**RE: West Central Complete Streets – Sarracino Pl to 98<sup>th</sup> St  
Preliminary Drainage Report – December 24, 2025  
Engineer’s Stamp Date: No Date  
Hydrology File: K09D045  
Case # HYDR-2026-00013**

Based upon the information provided in your submittal received 01/14/2026, the Preliminary Drainage Report **is not** approved for Work Order. The following comments need to be addressed for approval of the above referenced project:

# WEST CENTRAL COMPLETE STREETS SARRACINO PLACE TO 98<sup>TH</sup> STREET

PRELIMINARY DRAINAGE REPORT

## ALTERNATIVE #1 – DRAINAGE SWALES

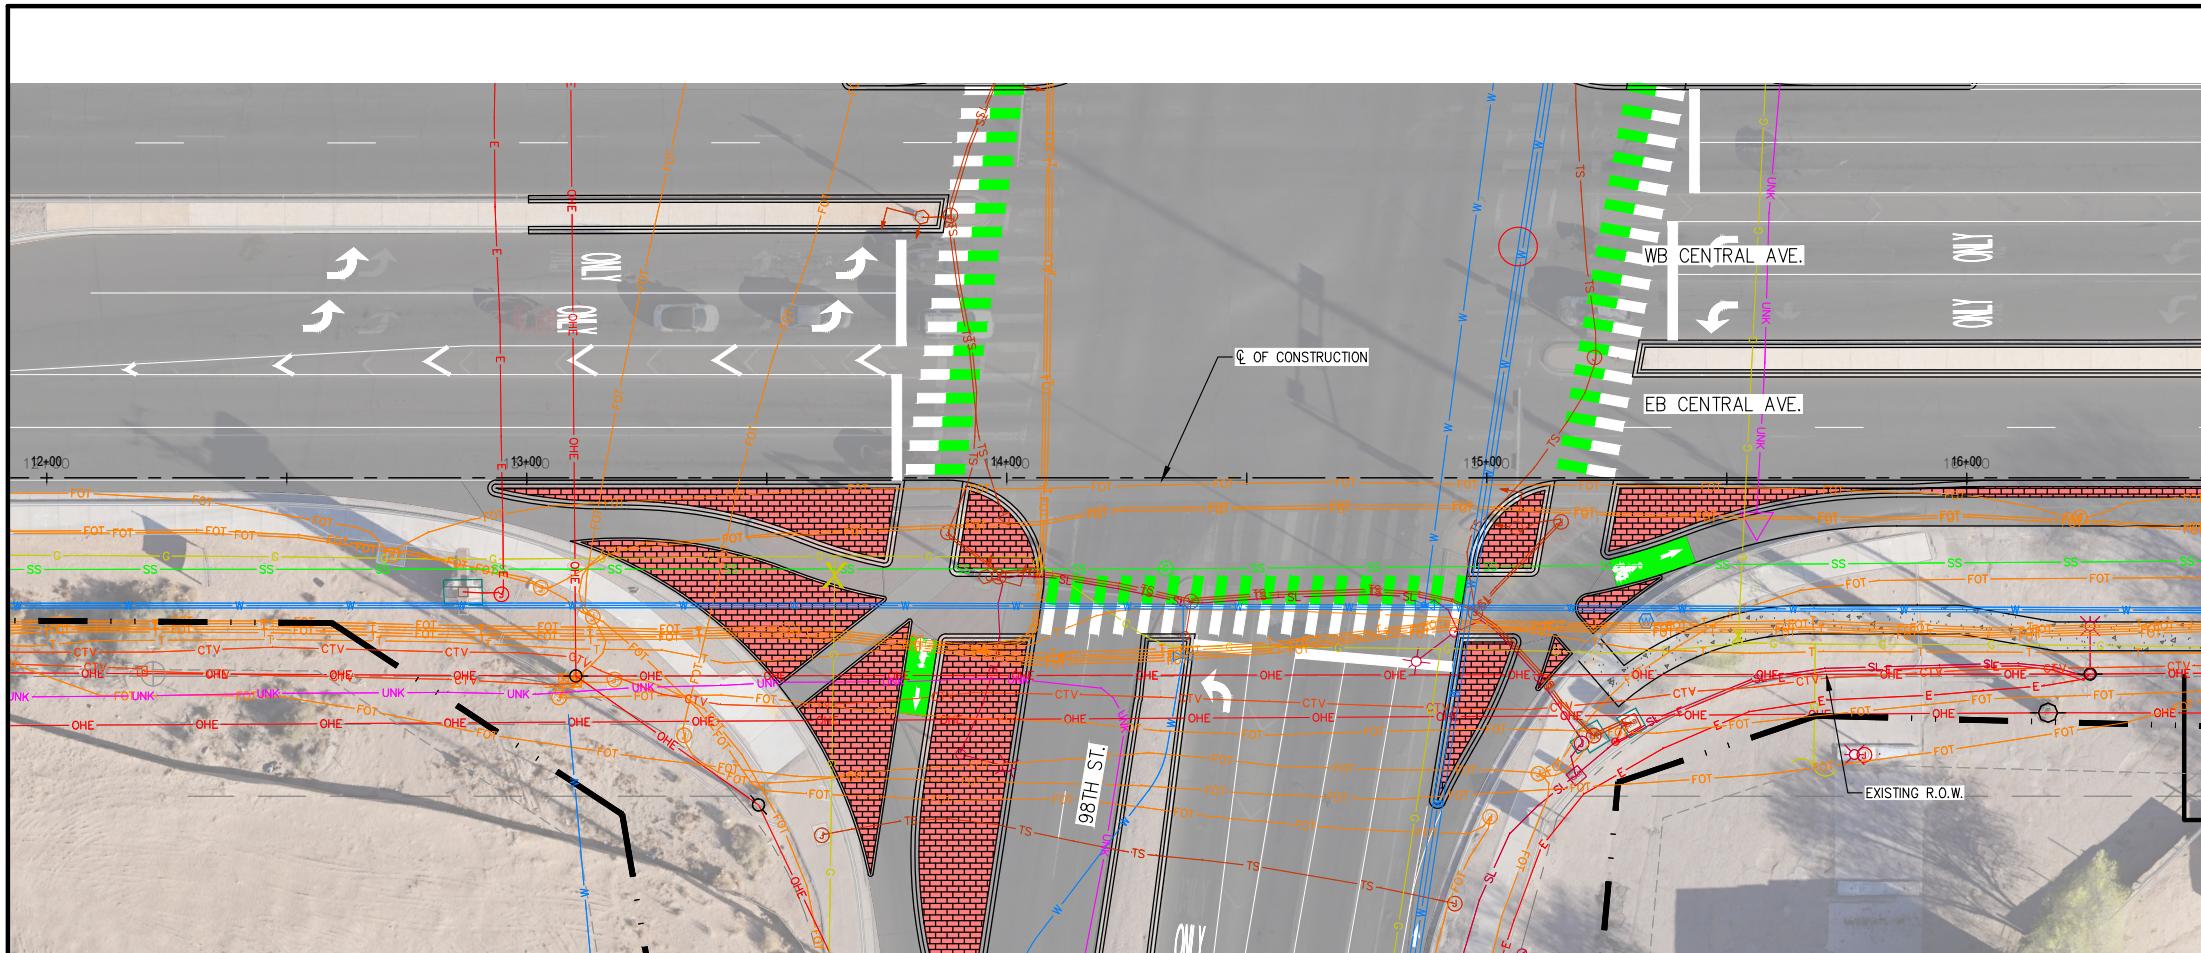
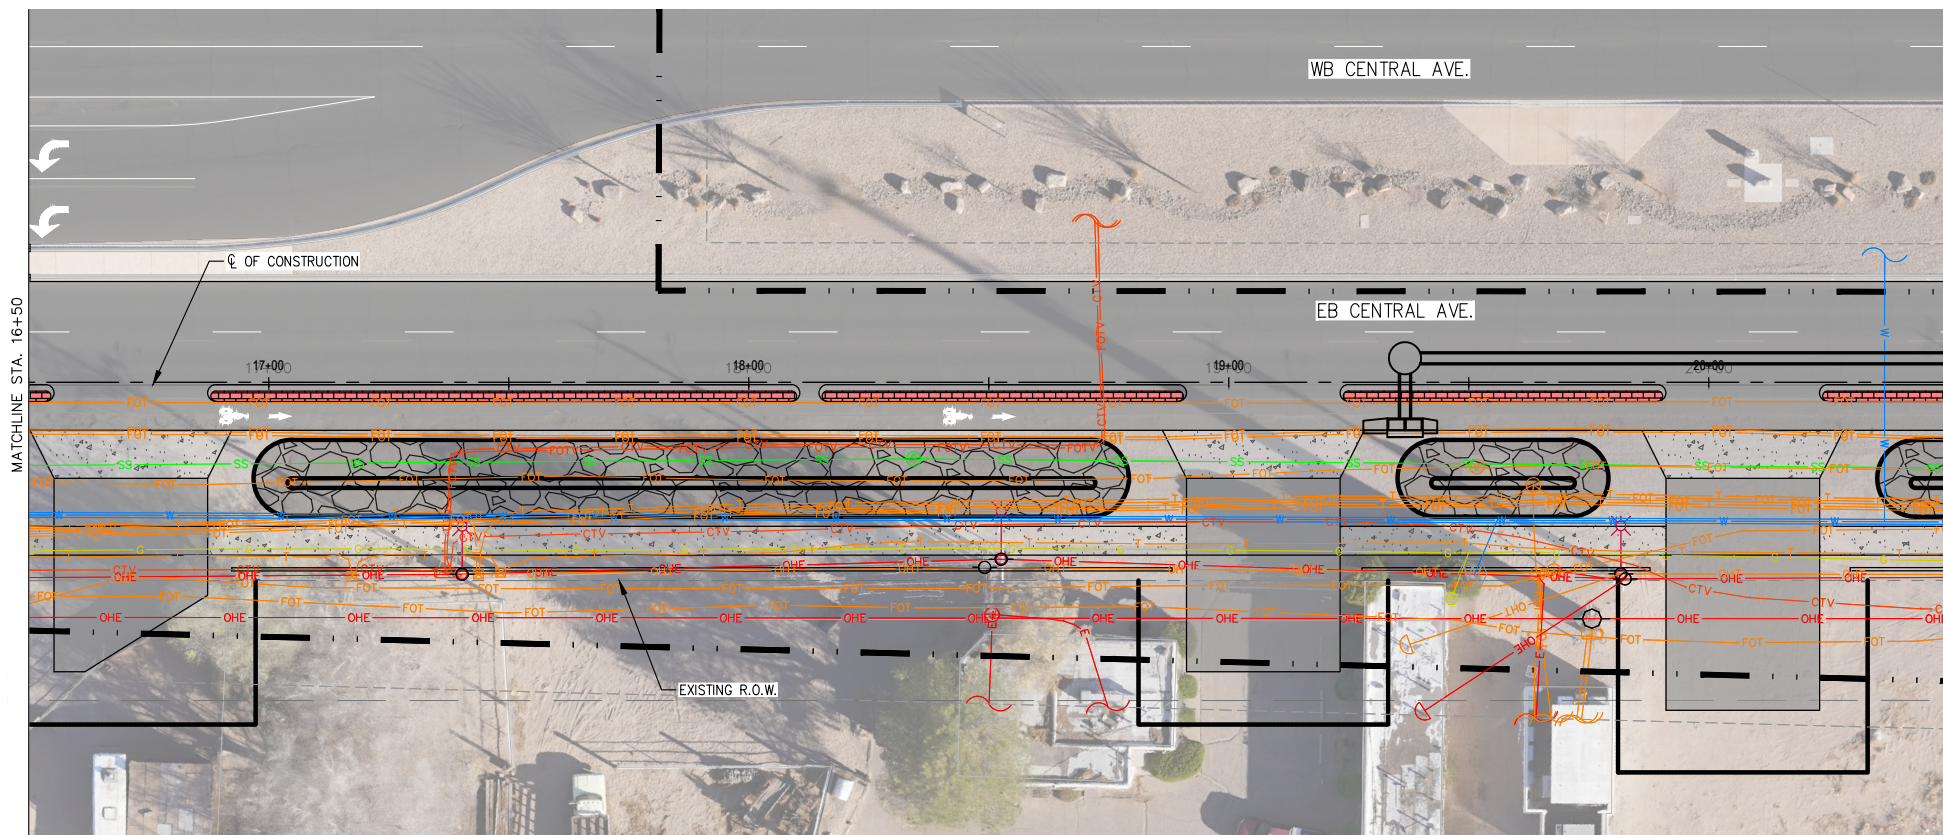
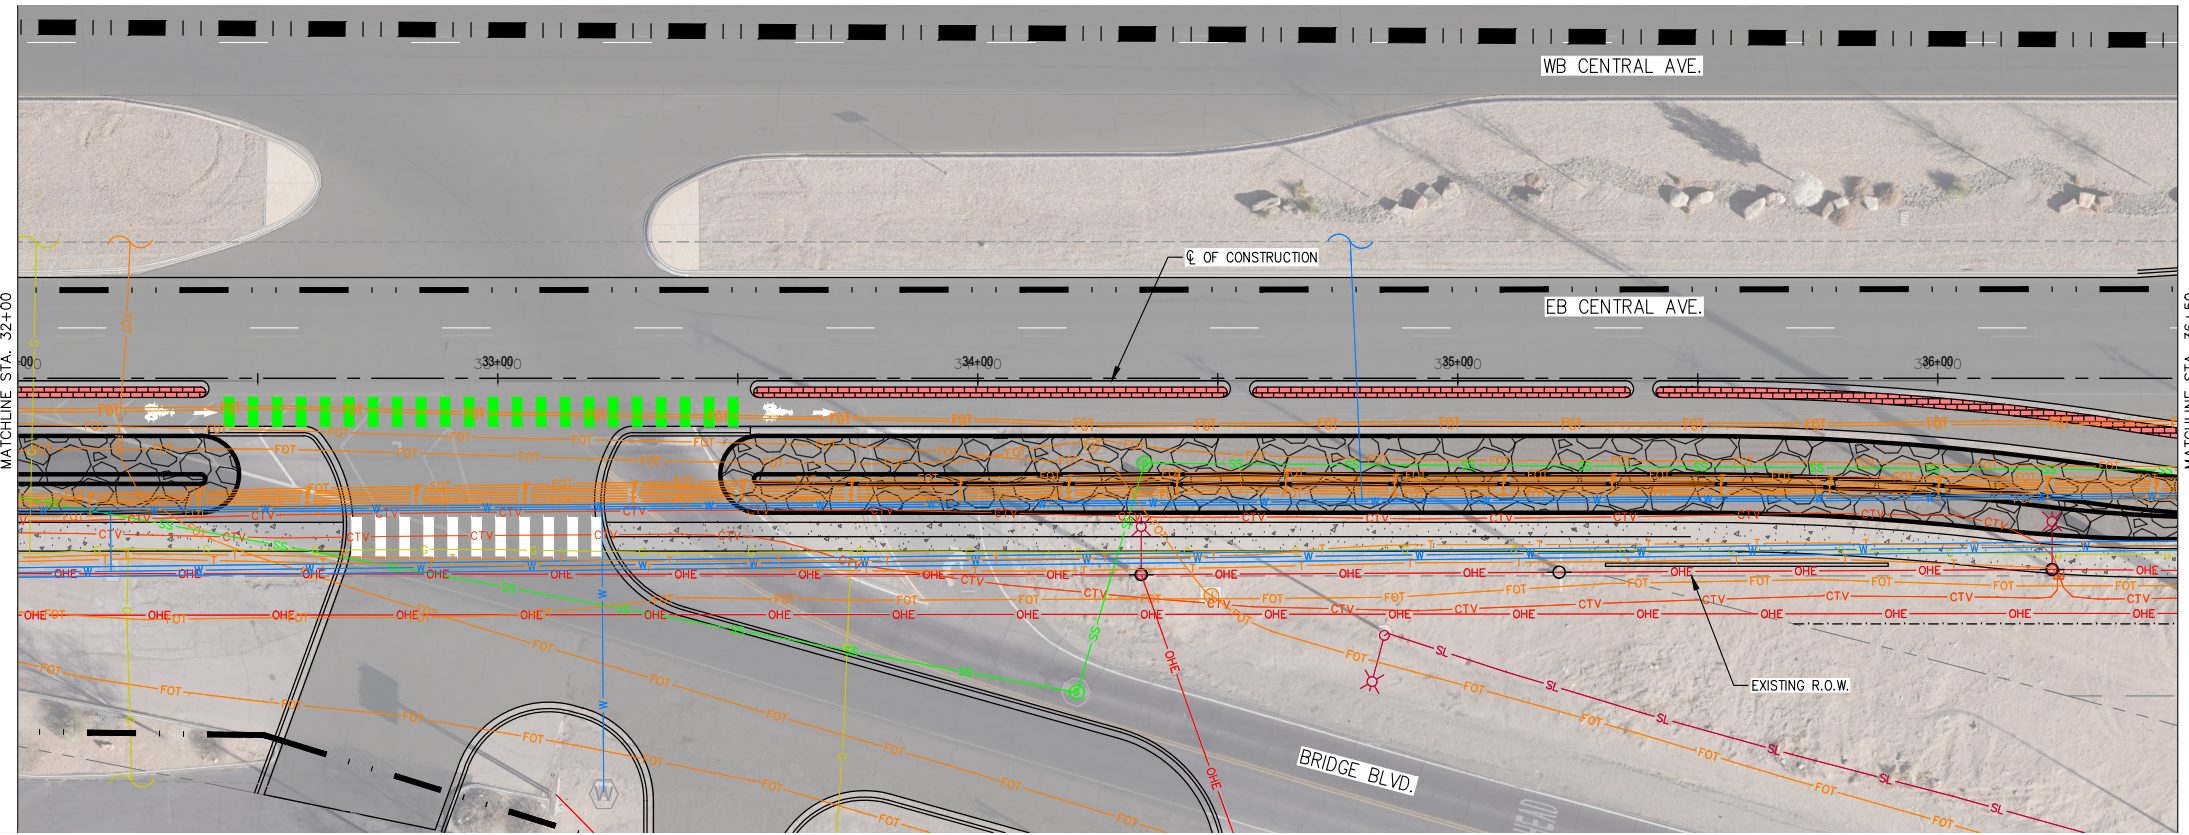
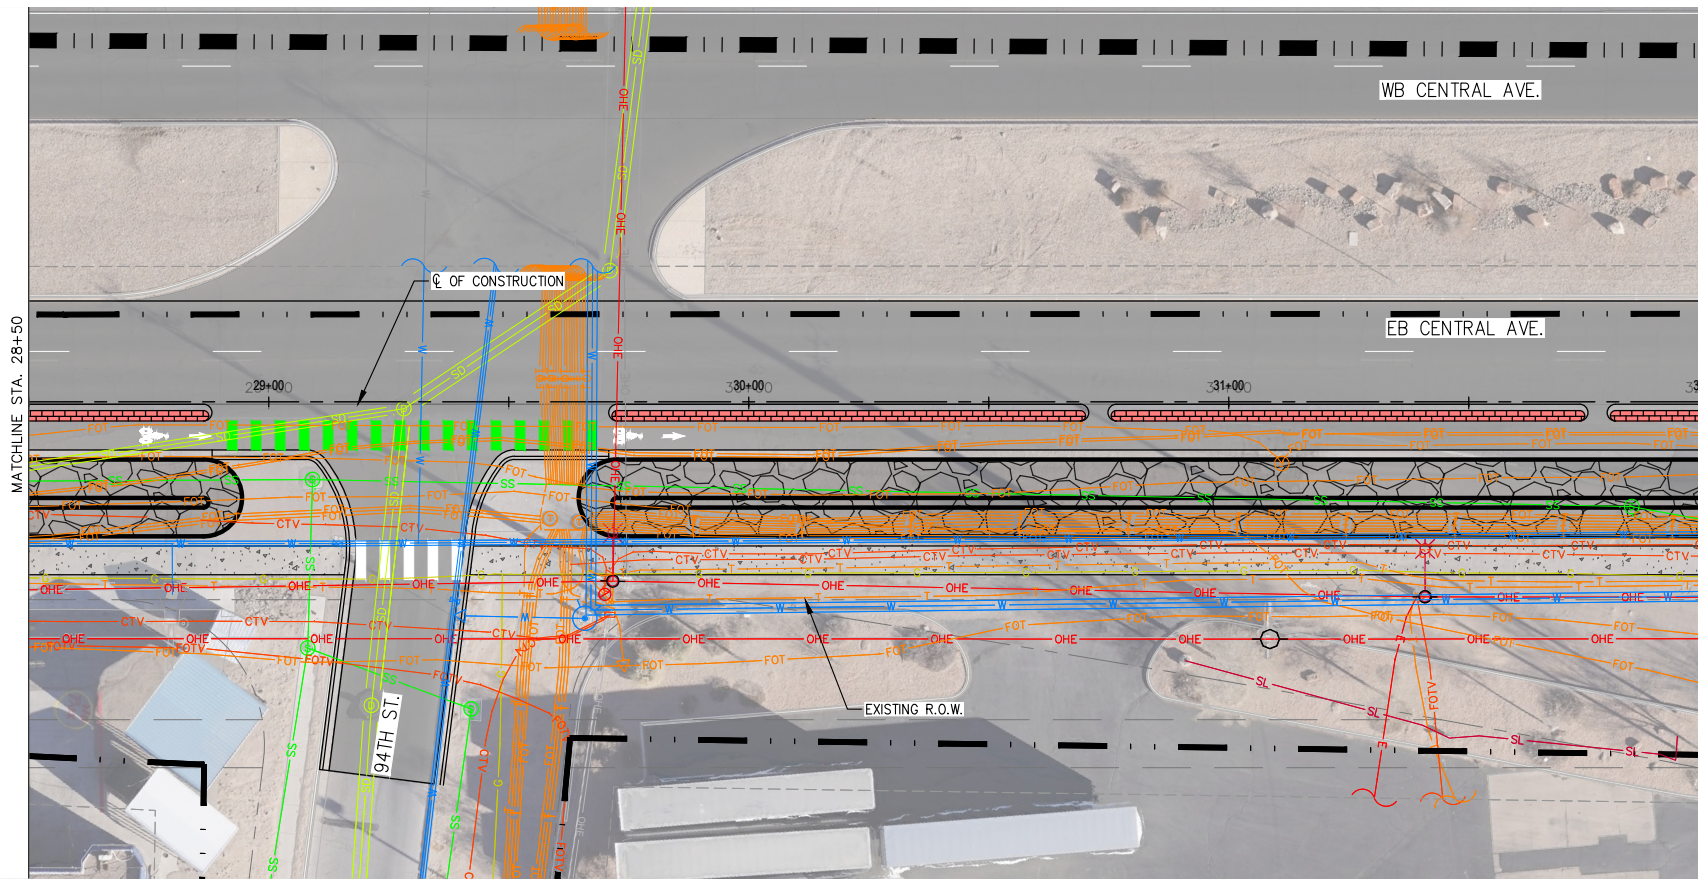
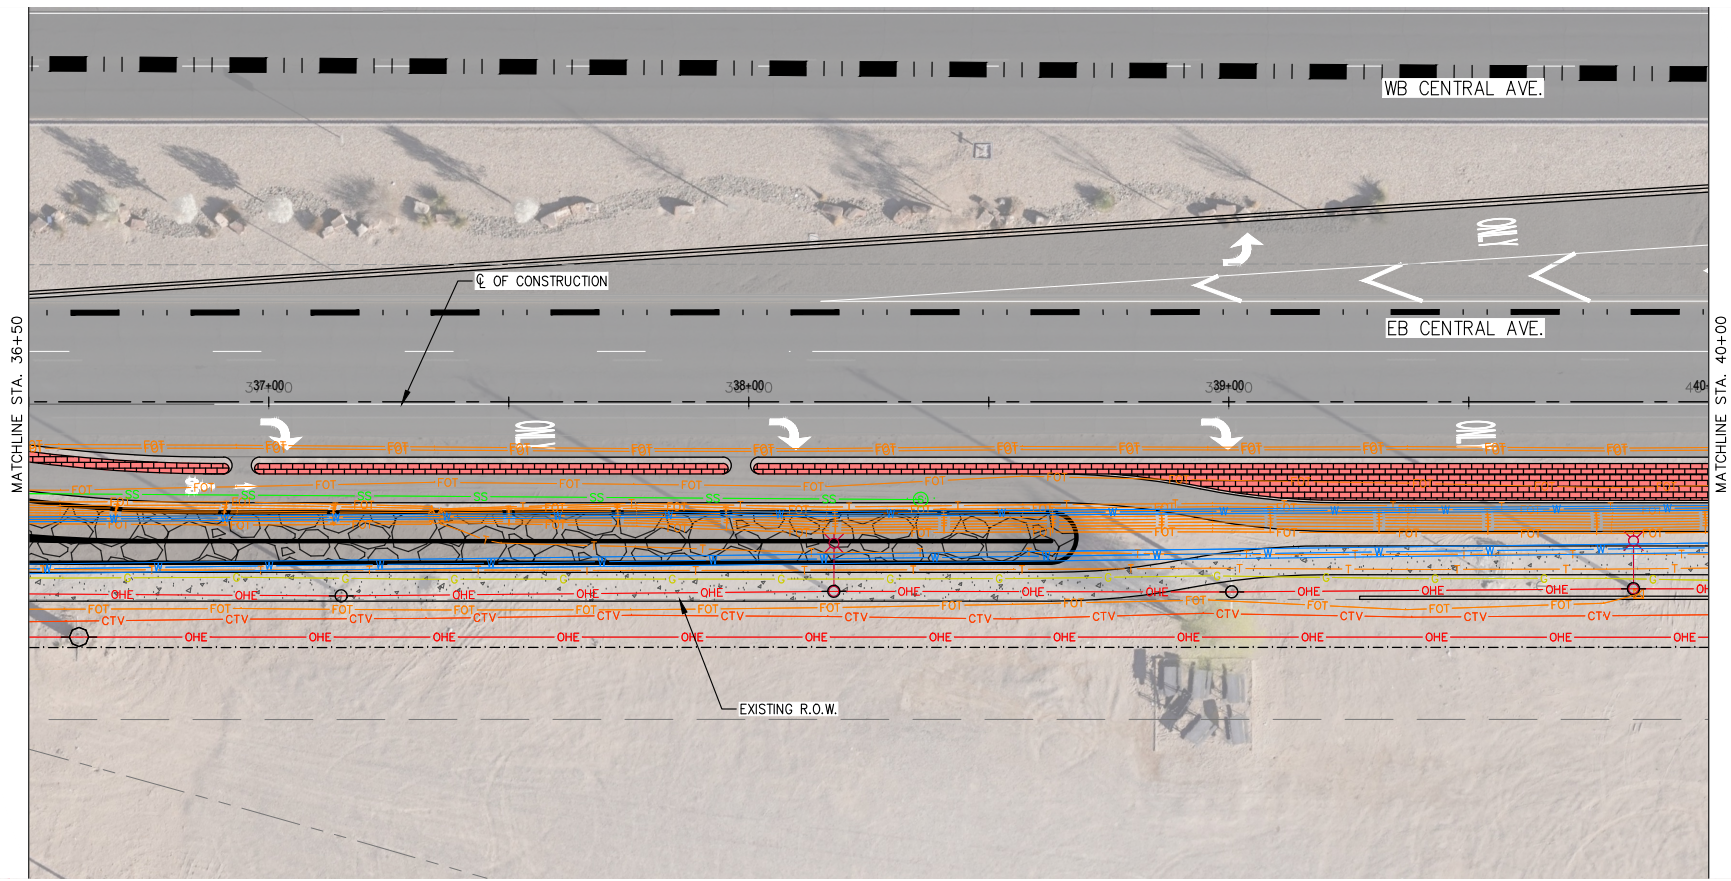
1. Please provide an engineer’s stamp with a signature and date.
2. Pg 68-71 – Add street names to the plan.
